**13 January 2023 – Deadline 5**

**Application by Sunnica Ltd for an Order Granting Development Consent for the Sunnica Energy Farm Project  
EN010106**

**This document sets out the Council's responses to the ExA's Second Written Questions (ExQ2)**

Drawing Number 60589004_ES_LSP_029B	Rev 0
---	-----------------

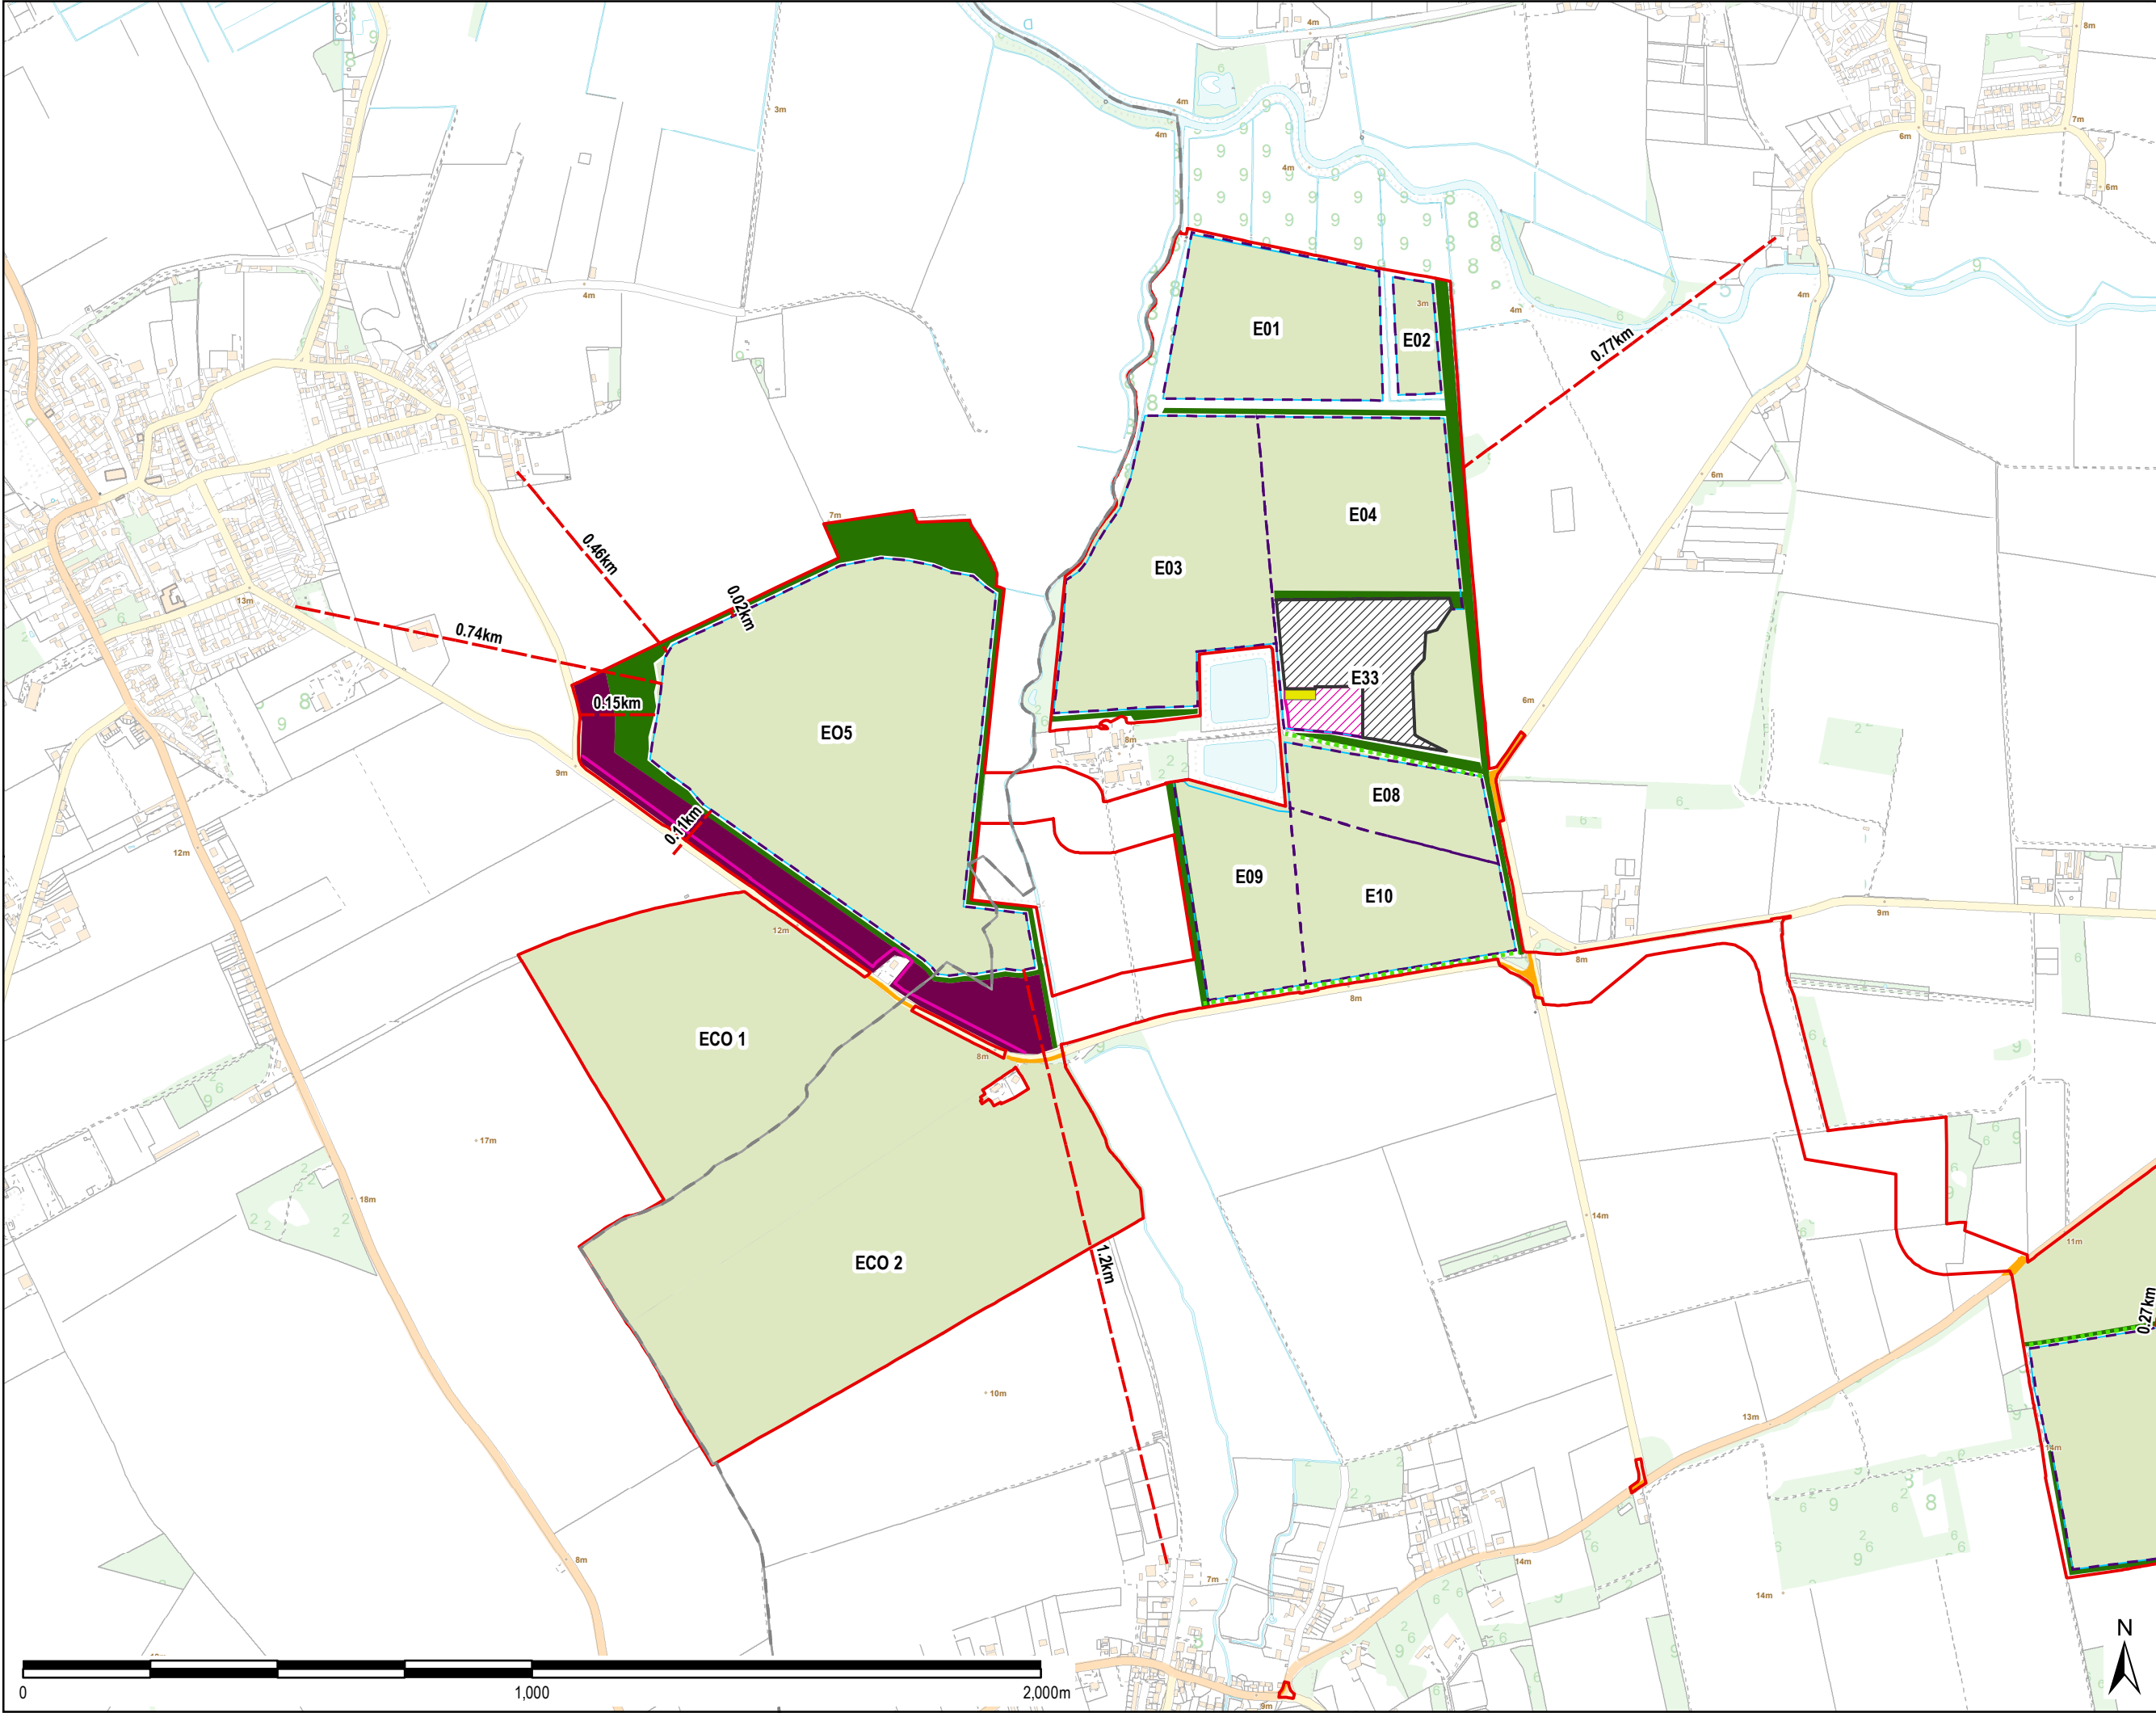
<p>The ES [APP-039] section 7.7.9 and 7.7.164 states that 'A number of areas in Sunnica East Site A will be required for Stone Curlew mitigation. These will be contained within the ECO1 and ECO2 areas (shown in Figures 3-1 and 3-2). These contain archaeological remains, which are assessed below. The Stone Curlew mitigation will comprise a non-intrusive methodology to establish grassland in these areas. These areas will be subject to further evaluation through trial trenching prior to preparation of the ground for ecological mitigation'.</p> <p>Section 7.7.165 states that 'It is anticipated that, subject to the continued usage of the non-intrusive methodology, the archaeological remains within the ECO1 and ECO2 areas will continue to be preserved in situ, and there will be no below ground impact. There is therefore no change anticipated to the asset'.</p> <p>Section 7.8.2 explains that 'Preserving assets in-situ would involve the embedded design measures, including: b. Minimising vegetation clearance, land disturbance and land take and consequent loss of archaeological remains'.</p> <p>LIR 7.42 [REP1-024] explains the importance of the ten areas of significant (high value) archaeological interest. The paragraph states that 'An Historic Environment Management Plan should be prepared to provide a mechanism by which these sites will be suitably protected under pasture, managed and maintained - indicating by whom throughout the life of the solar farm, along with proposals for what will happen to them should the site be decommissioned and dismantled'.</p> <p>LIR 7.46 states that 'Environmental Management Plans should include a section for Heritage Management. Sites that are to be protected under grass should include appropriate schedules of cutting and de-scrubbing to prevent invasive roots or matting to occur that would require future invasive mitigation need, the avoidance of which is desirable'.</p> <p>Historic England provide guidance on the preservation of archaeological sites in situ [Annex A]. The guidance requires maintenance of a closed grass sward with little, if any, soil intrusion or chemical input that might change existing soil conditions.</p>

<p>Offsetting Habitat Provision for Stone-Curlew Specification [APP-258] sets out the requirements for ECO1, ECO2 and ECO3. It states that Stone Curlew nest plots will be established using various cultivation techniques to create a rough tilth and or bare ground 'depending on ground conditions and other environmental constraints'. In addition, 108ha of close-cropped grassland will be created, which within Sunnica East site A will be chalk grassland. Within Sunnica East site B the grassland is intended to be semi-natural grassland, characteristic of the Brecks heaths.</p> <p>The document sets out that within areas ECO1 and ECO3 the Stone Curlew plots will be created following the recommendations in guidance provided by RSPB and in the Countryside Stewardship Higher Tier guidance (4.1.9), and a cultivation programme (which replicates the RSPB guidance) is set out in section 4.1.11. This guidance is not referred to in section 4.1.12 - 4.1.15 'Establishment and management of plots and grassland in archaeological areas (ECO2)'.</p> <p>LIR 8.63 points out inconsistencies in which area, ECO1 and/or ECO2, is archaeological mitigation and the concern that there are potentially conflicts in managing the area for both archaeology and for Stone Curlew.</p> <p>Natural England's guidance on the provision of Stone Curlew mitigation is set out in the advice note 'Sourcing and managing mitigation land' [Annex B]. This explains that 'Stone Curlew generally nest in open fields with dry soil, with areas of dry, bare, stony ground or low vegetation'. The guidance sets out how Stone Curlew offsetting land can be established and managed.</p> <p>Aspects of the Stone Curlew offsetting which have the potential to cause conflict with preservation and management of archaeological interest include:</p> <ul style="list-style-type: none"><li>• Reduction of nutrient levels prior to the establishment of grassland</li><li>• Establishment of grassland</li><li>• Management of bare ground nesting plots</li><li>• Management/grazing of grassland.</li></ul> <p>The archaeological requirements /constraints include:</p> <ul style="list-style-type: none"><li>• Disturbance or intrusion of the topsoil must be minimised/avoided including topsoil removal or inversion</li></ul>

- Additions to the existing topsoil can alter the PH of the soil and harm buried archaeology. This includes chemicals which should be minimised
- Cultivation of topsoil is limited to disc harrowing or drilling, and ploughing should be avoided
- The grassland should be a closed grass sward maintained to prevent scrub development
- Bare ground should be avoided to prevent wind blow which might expose buried archaeology
- Disturbed ground plots can be delivered where trial trenching has demonstrated that buried archaeology is not present. Areas where trial trenching has been undertaken is illustrated at Annex 3 - 6.2 Appendix 7H: Sunnica East Sites A and B Archaeological Trial Trenching Report [PDA-002]
- Grassland maintenance could include grazing by sheep or mechanical topping/mowing
- Grazing by rabbits must be avoided because of the disturbance rabbits' cause.

<ul style="list-style-type: none"> <li>• Reduction of key soil nutrients from the arable land is required to achieve semi-natural grassland, required prior to grassland establishment. There are several techniques to achieve this.</li> <li>• For grassland establishment natural regeneration is the preferred technique with active weed management.</li> <li>• Ideally management of a low sward would be achieved through intense grazing by rabbits and controlled livestock grazing.</li> <li>• Mowing outside the breeding season particularly in early years of vegetation establishment.</li> <li>• Scope to adapt and change management prescriptions should the offsetting land not deliver on the objective to achieve 'no net loss of stone curlew in and around the scheme.'</li> </ul> <p>ECO1 – this area is known to be of high archaeological value and is shown as archaeological mitigation on the Environmental Masterplan. Trial trenching has identified two areas where the 2ha disturbed Stone Curlew ground plots can be delivered. The third area tested by trial trenching is unacceptable to the County archaeologists. The Stone Curlew nesting plots shown on the Environmental Masterplan do not correspond to the locations that are acceptable to the County archaeologists.</p> <p>ECO2 – this area is also known to be of high archaeological value but is not shown as archaeological mitigation on the Environmental Masterplan. Trial trenching has identified three areas where the 2ha disturbed Stone Curlew ground plots can be delivered. The Stone Curlew nesting plots shown on the Environmental Masterplan differ from these trial trenching locations and include areas unacceptable to the County archaeologists.</p> <p>ECO3 – the archaeological interest of this area has not been fully investigated. The area has been shown to contain some archaeology through geophysical survey but has not been evaluated. No trial trenching has been undertaken and therefore the delivery of bare ground plots in this area remains unknown.</p> <p>The Councils are currently not satisfied that all the conflicts between the preservation of archaeology within the site and the delivery and maintenance of</p>

<p>stone curlew offsetting have been reconciled. The concern is that currently it is not certain that the ten 2ha disturbed ground plots can be delivered. In addition, it is not clear whether the archaeological constraints will further restrict the ability to deliver the 16ha of top-quality habitat per Stone Curlew pair. The Council is also concerned that the archaeological constraints will restrict management of the area in the future and limit any adaptive management measures that might be necessary to the effectiveness of the stone Curlew Offsetting land particularly as there is currently no contingency for the situation that the Stone Curlew mitigation strategy is not effective.</p>
Q2.10.6	<p><b>Baseline conditions</b></p> <p>We note the Applicant's response to our ExQ1.10.81 [REP2-037] relating to baseline traffic conditions [REP2-037], where it is stated that "The LHAs concern was whether there was a scenario where construction flows and baseline flows combined were likely to be higher than in the weekday assessment, and not whether there would be a higher proportionate impact". Surely a Saturday assessment should be undertaken as the additional weekend construction traffic will be proportionally higher and impact more on peaceful enjoyment?</p>	<p>Based on the Applicant's submissions, including the Framework Construction Traffic Management Plan [REP3A-004], the Council's Environmental Health Team is satisfied that, from a public health perspective, that a Saturday assessment is not required on noise grounds.</p> <p>The Council supports SCC's response to this question in relation to highway matters.</p>
